Response to Planning application from Hertfordshire County Council (T and CP GDP Order 2015)

District ref: 6/2022/0837/ADV
HCC ref: WH/11934/2022
HCC received: 11 May 2022
Area manager: Matthew Armstrong
Case officer: Steven Knight

COTE BRASSERIE 1-3 HOWARDSGATE WELWYN GARDEN CITY AL8 6AL

Installation of 2 sets of halo illuminated fascia text and 2 externally illuminated projection signs

Proposed Signs

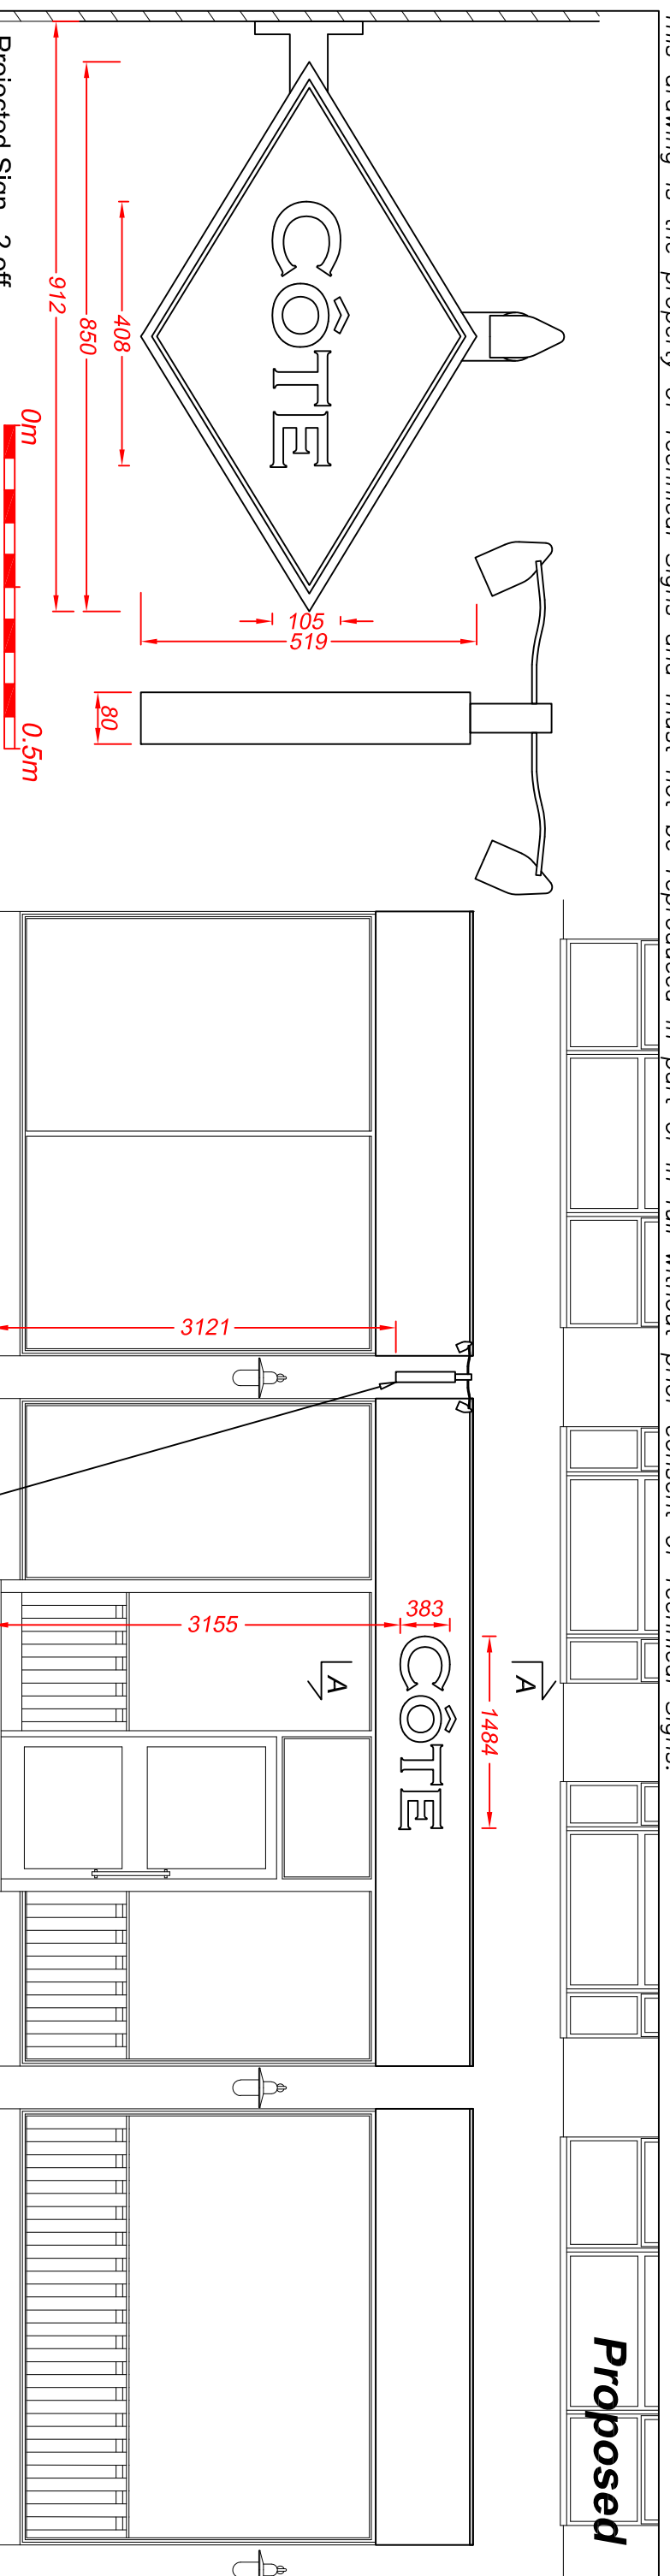
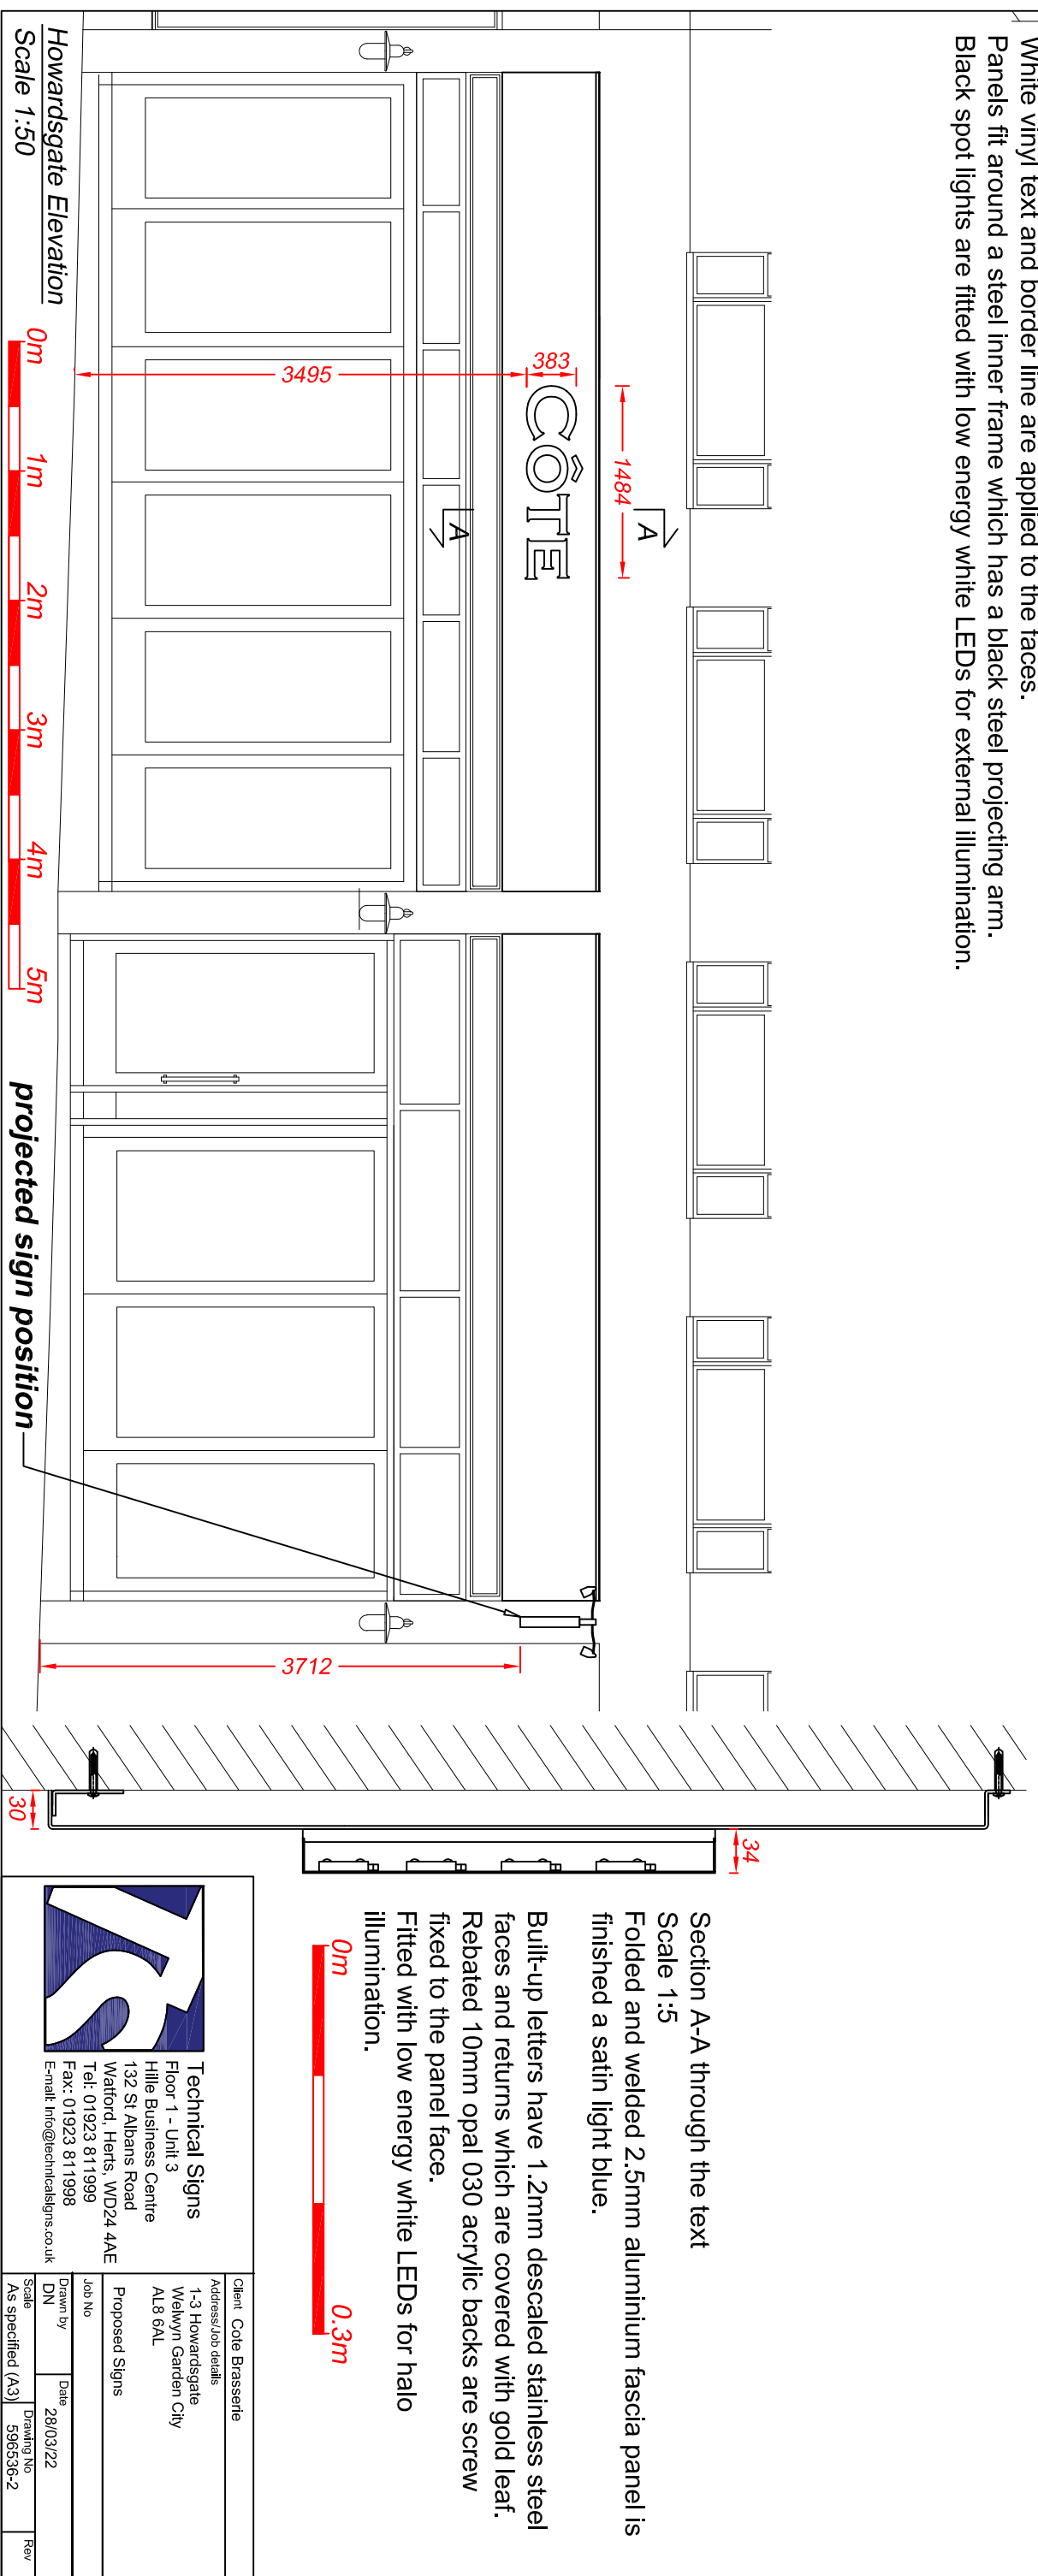
The highway authority previously responded to this application on 22 April and raised no objections. The proposed halo illumination of the fascia signs has now been changed to trough lighting. The proposed trough lights are just under 4m above the footway so will not present a danger to pedestrians. The highway otherwise refers to its previous response which has been included below for reference:

The proposed signs will replace existing fascia and projecting signs so do not represent an increase in signage or visual clutter.

The luminance of the proposed signs is within acceptable limits based on the ILP's Professional Lighting Guide 05 – The Brightness of Illuminated Advertisements. This is an urban, street lit area with multiple other similar signs so the proposal is unlikely to be distracting or confusing to motorists.

The fascia signs will be flush to the shopfront and the projecting signs will be over 3m above the footway which is acceptable.

Notice is given under article 22 of the Town and Country Planning (Development Management Procedure) (England) Order 2015 that Hertfordshire County Council as Highway Authority does not wish to restrict the grant of permission subject to the following conditions:

Prior to the first use of the development hereby permitted the intensity of illumination shall be provided at a level that is within the limit recommended by the Institution of Lighting Professionals in the publication 'Technical Report No 5: Brightness of Illuminated Advertisements' and 'Guidance Note for the Reduction of Obtrusive Light GN01:20'.
